Application by RWE Renewables UK Solar and Storage Limited for Peartree Hill Solar Farm (EN010157)

The Examining Authority's (ExA's) third written questions and requests for information (ExQ3)

Issued on Friday 14 November 2025

### Figure 14.2: Transport Routing and the Existing Highway Network

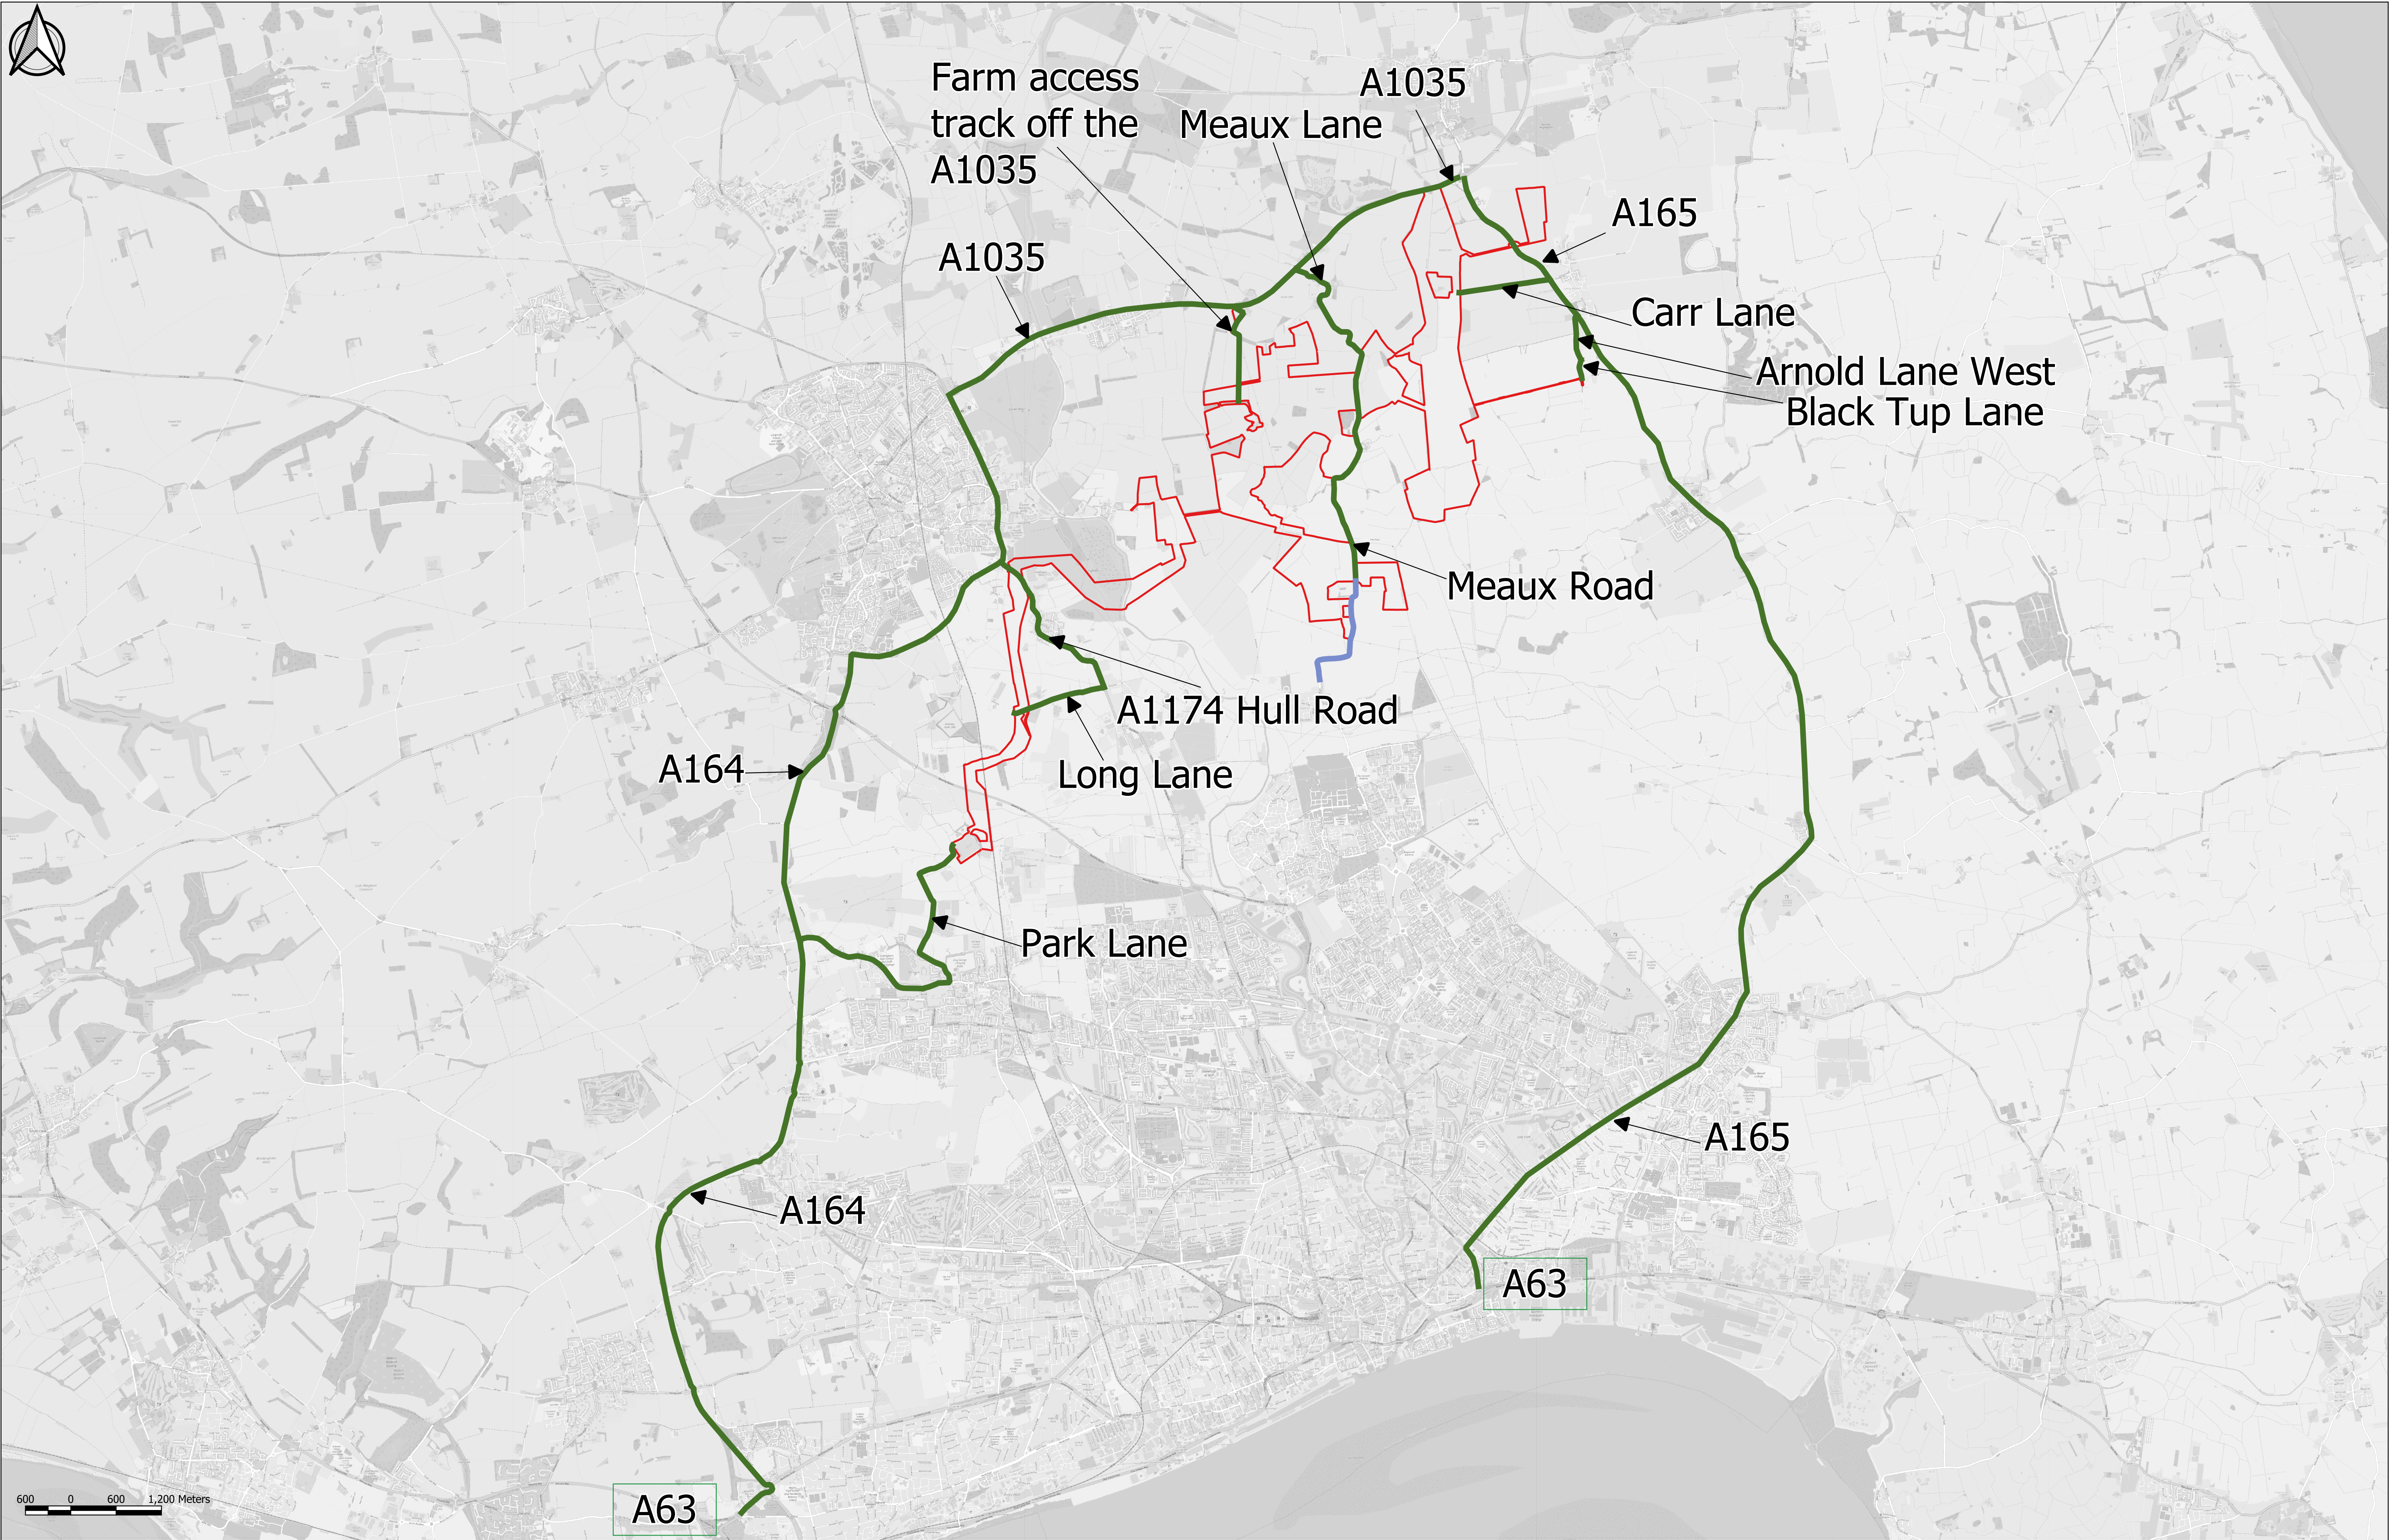
4. Need, site selection and alternatives		
No further questions at this time		
5. Air quality		
3.5.1	Applicant	Air Quality Management Area (AQMA) Notwithstanding your response to ExQ1.5.3 [REP1-073], please: <ul style="list-style-type: none"> a) Clarify which sections of roads identified on ES Figure 14.1: Study Area for Transport and Access [REP2-120] and ES Figure 14.2: Transport Routing and the Existing Highway Network [REP2-121] travel through the AQMA;

ExQ3	Question to:	Question:
		<p>b) Clarify whether, having regard to Table 6-10 of ES Chapter 6: Air Quality [APP-042], any changes in light/ heavy duty vehicle flows through the AQMA would exceed 100/ 25 annual average daily traffic (AADT) respectively;</p> <p>c) If the relevant AADT would be exceeded, provide further justification for a lack of an air quality assessment in this regard and your conclusion that “[...] <i>the road traffic exhaust emissions from the Proposed Development traffic would not cause a significant effect on Hull AQMA 1.</i>”, noting the requirements of NPS EN-1 paragraphs 5.2.8 to 5.2.19; and</p> <p>d) Consider whether any amendments to the Policy Accordance Tables in Appendix 1 of [REP4-055] or any other documents are necessary in light of the AQMA.</p>

3.13.4	Applicant	Study area/ transport routes Please clarify the relationship/ consistency between the information shown on ES Figure 14.1 [REP2-120] and ES Figure 14.2 [REP2-121].

Revision 2

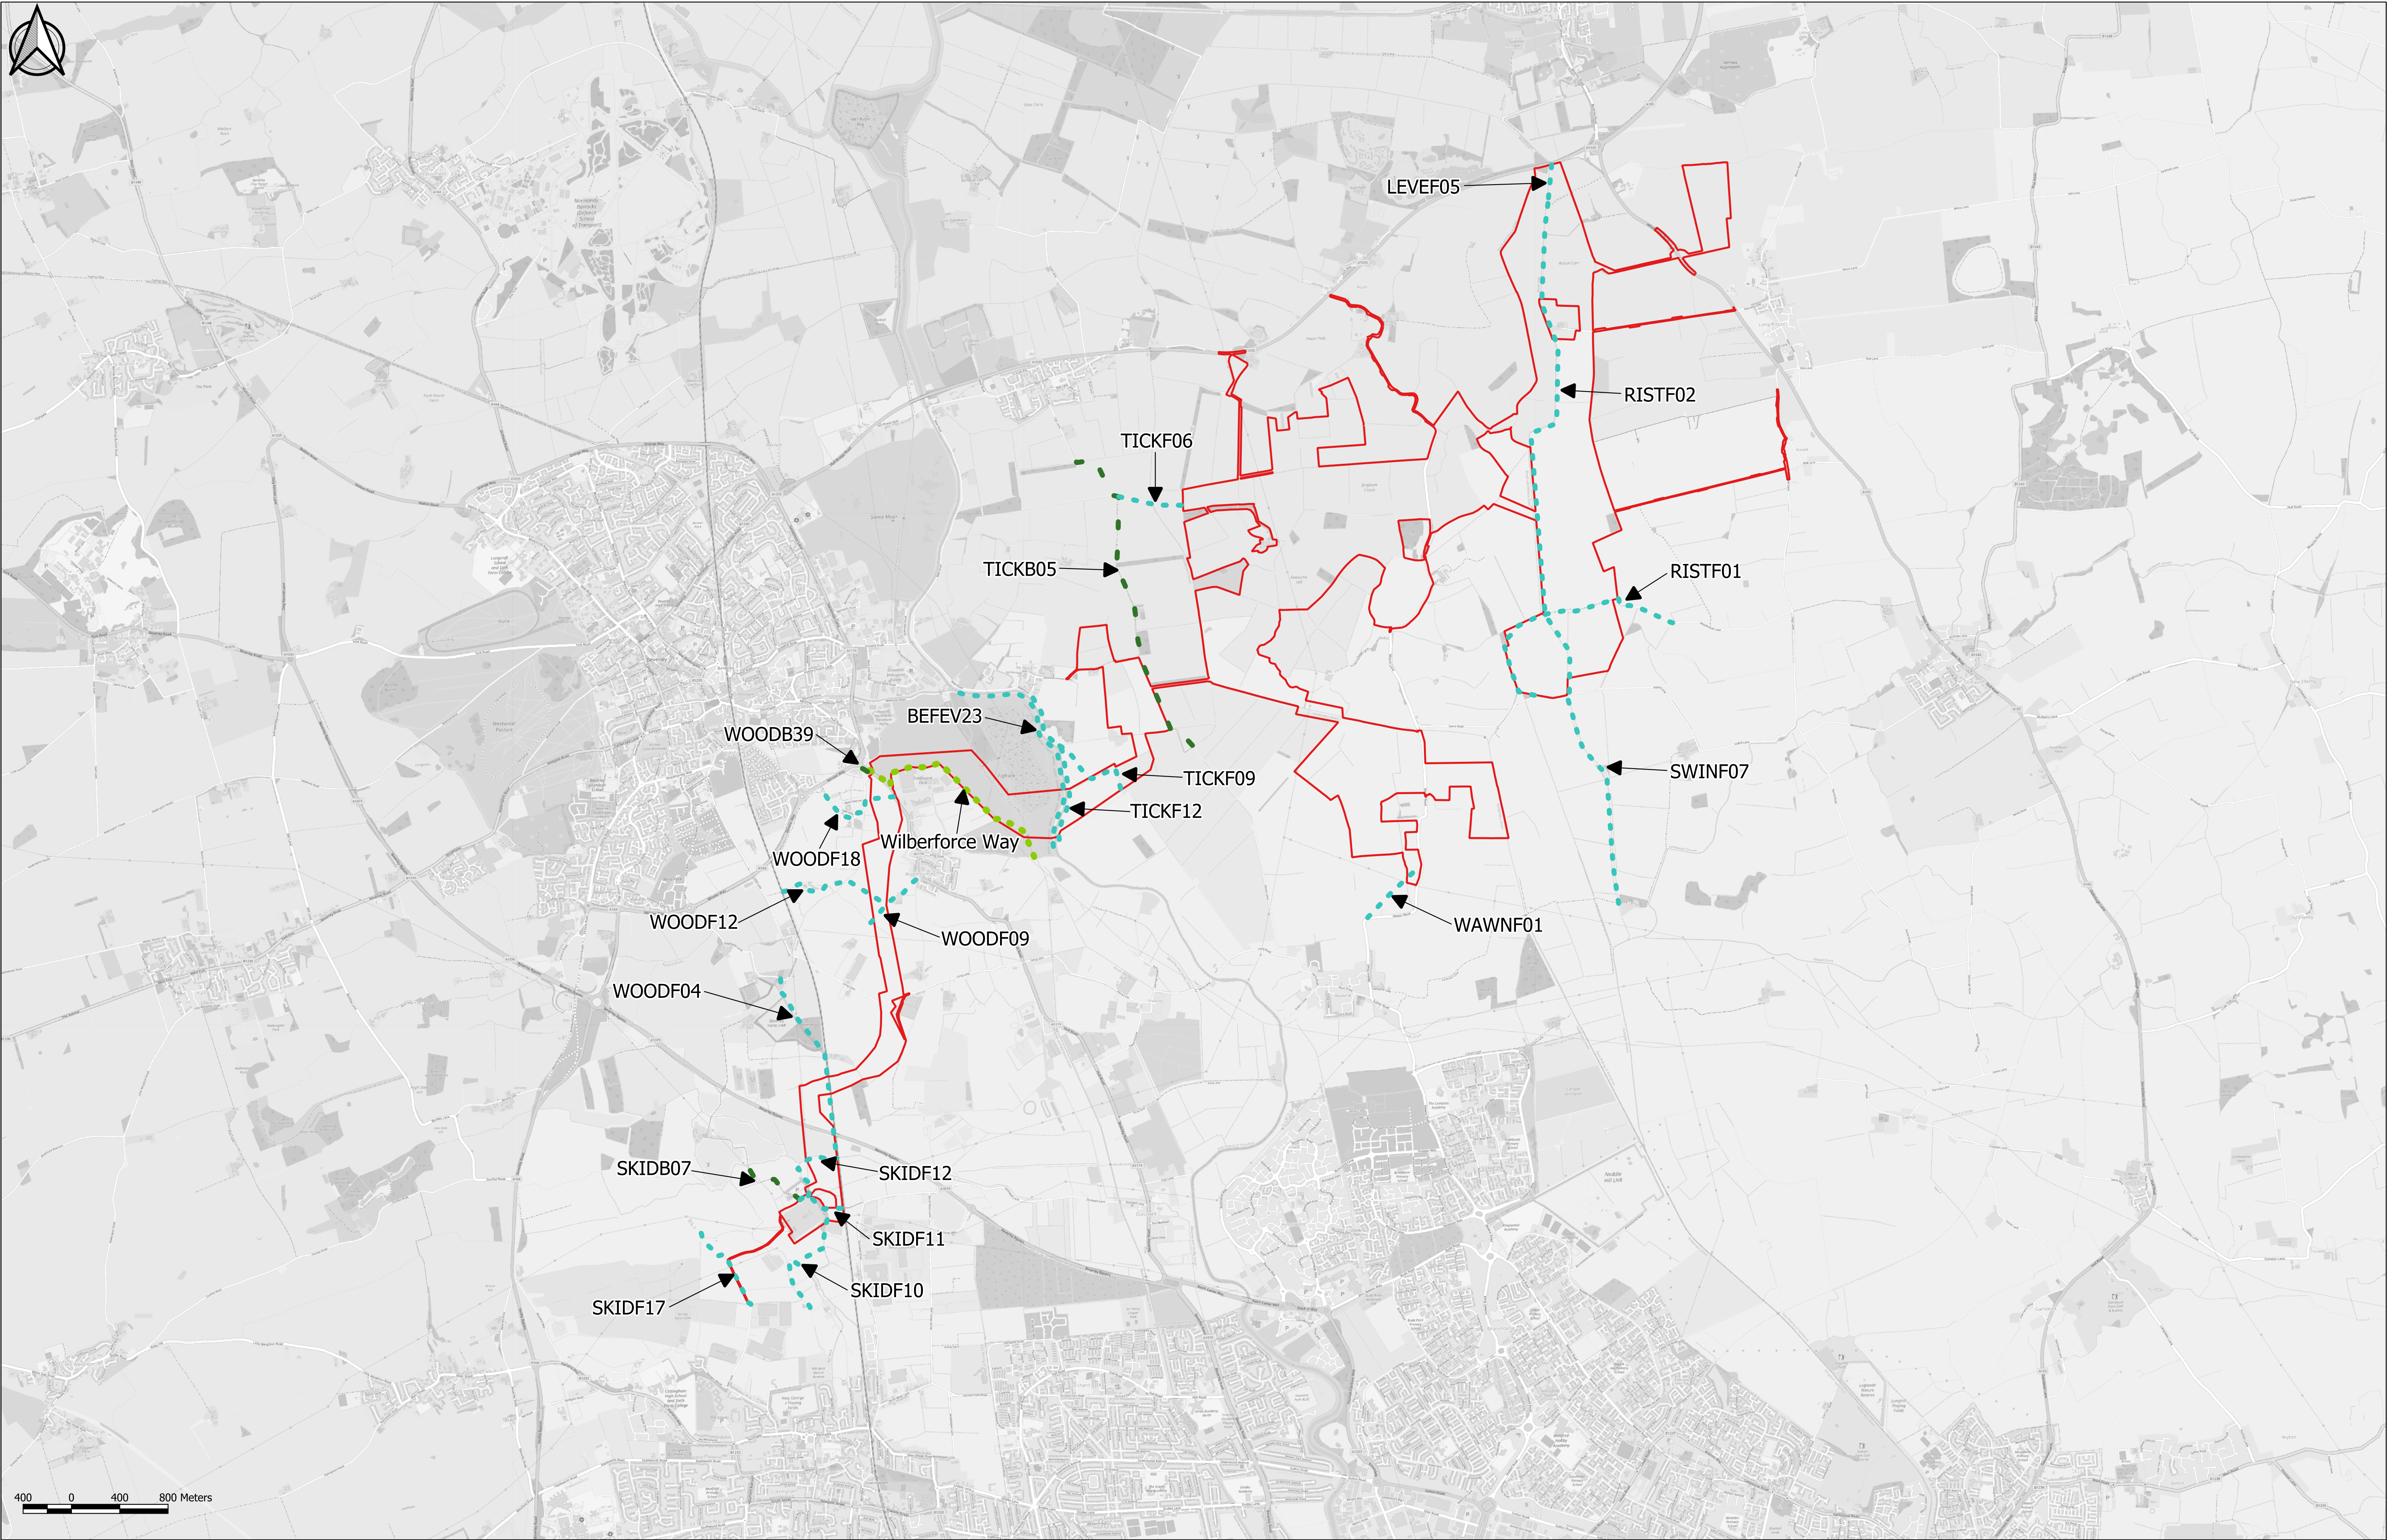
14. Cumulative		
3.14.1	Applicant	Intra-project combined effects a) Due to 'restrictions' it would be subject to, Riston Footpath No. 2 was added back into Sch 5, Part 2 of the dDCO [REP4-005] – in light of this, should any reconsideration be given to amendments to ES Chapter 15: Cumulative Effects (see tracked version [REP2-084]/ clean version [REP2-083]), such as at Table 15-4, Table 15-6 and paragraph 15.6.3; and b) Please confirm whether 'Wawne PRow located between Weel and Wawne' as cited in ES Chapter 15 [REP2-083] is the same footpath as that cited as 'WAWNF01' in other plans and document (such as ES Figure 14.3 [REP2-122] and ES Chapter 13: Population [REP4-065]).
